**ADC Planning Consultation
Response from the Historic Buildings Adviser**

Application Number	BR/143/14/A
Address	Hotham Park café, Upper Bognor Road, Bognor Regis
Description	3 No. non-illuminated fascia signs
Case Officer	Simon Davis
Site Visit

SCALE	DRAWN BY	DATE
1:100@A3 / 1:50@A1	PLB	DEC 13
DWG NO	340/03	REV. E

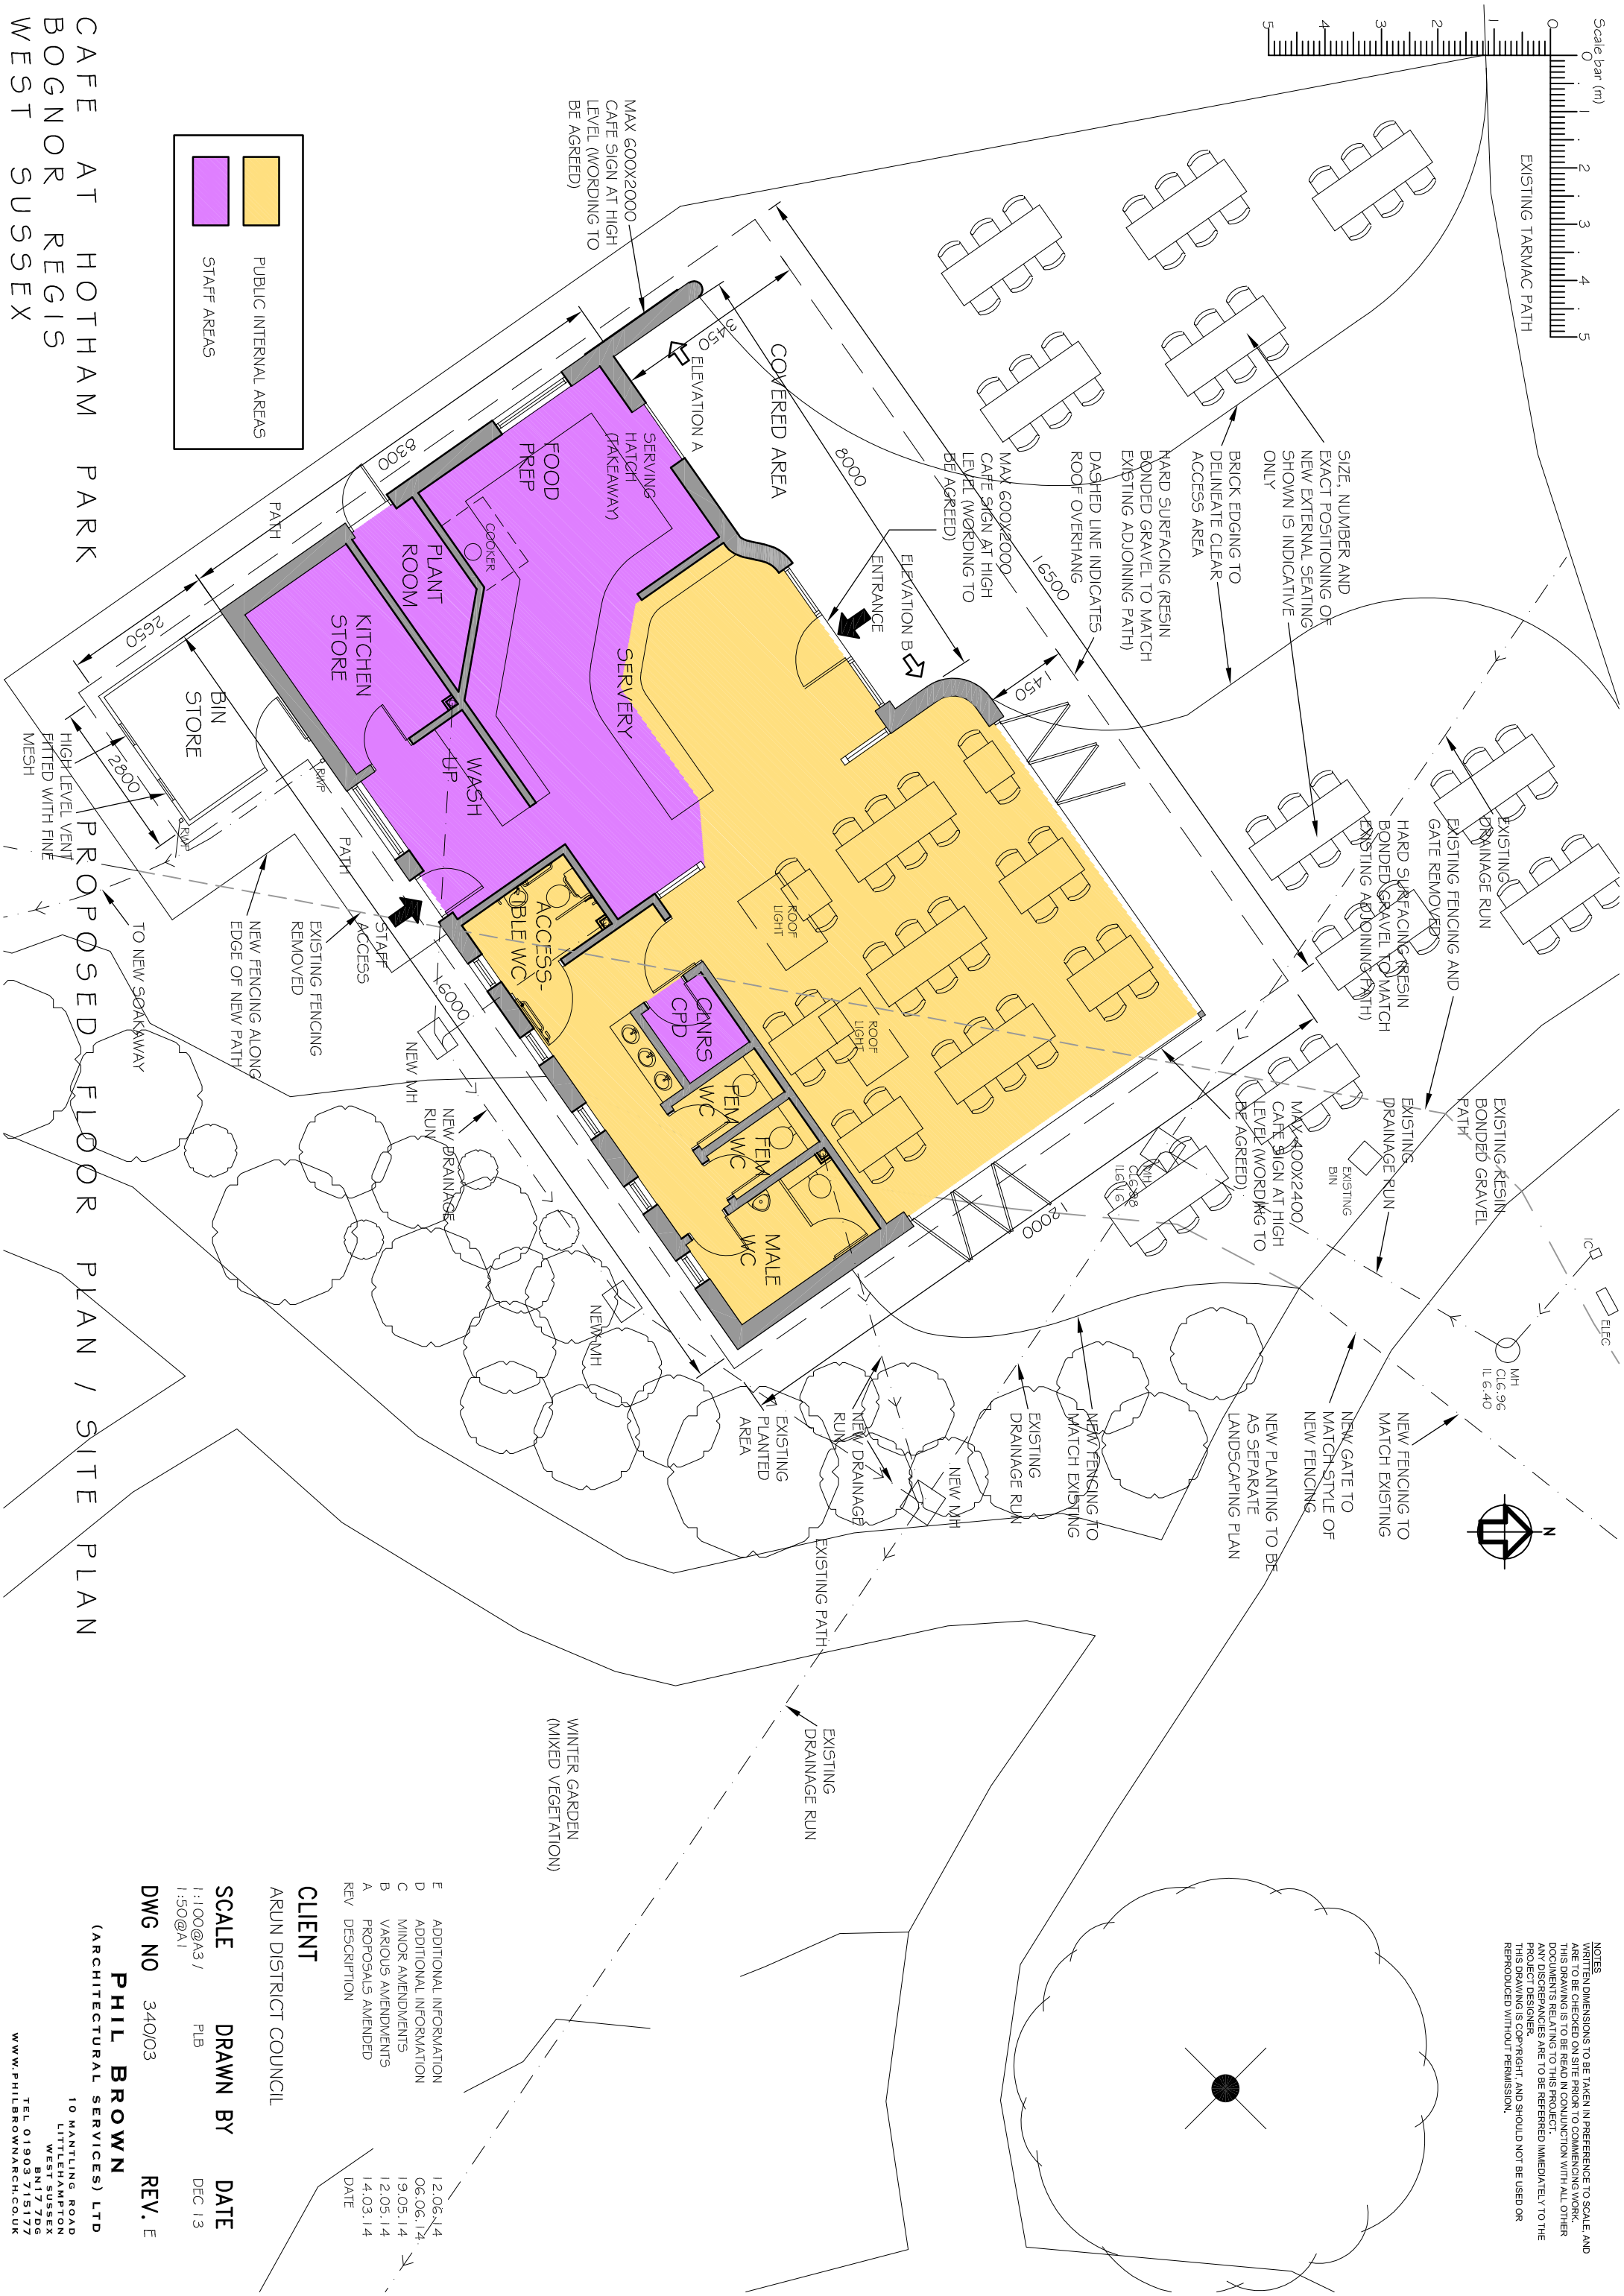
Whilst there is of course, no objection to the principle of signage, the proposed scheme does not correlate particularly well with the building. The three signs appear simply as boards attached around the building and are not integrated with the design at all. For example, the sign on the front elevation might be improved if it was the same width as the opening and perhaps not as deep. Meanwhile those to the side appear to be crammed up under the eaves.

As with the design advice for the building, the signage would benefit from a potentially more creative solution: letters might be mounted up on the front of the roof; the name could be etched in the glass, or applied to the timber side elevations. Whatever the approach, it should not appear as an after thought but part of the overall concept.
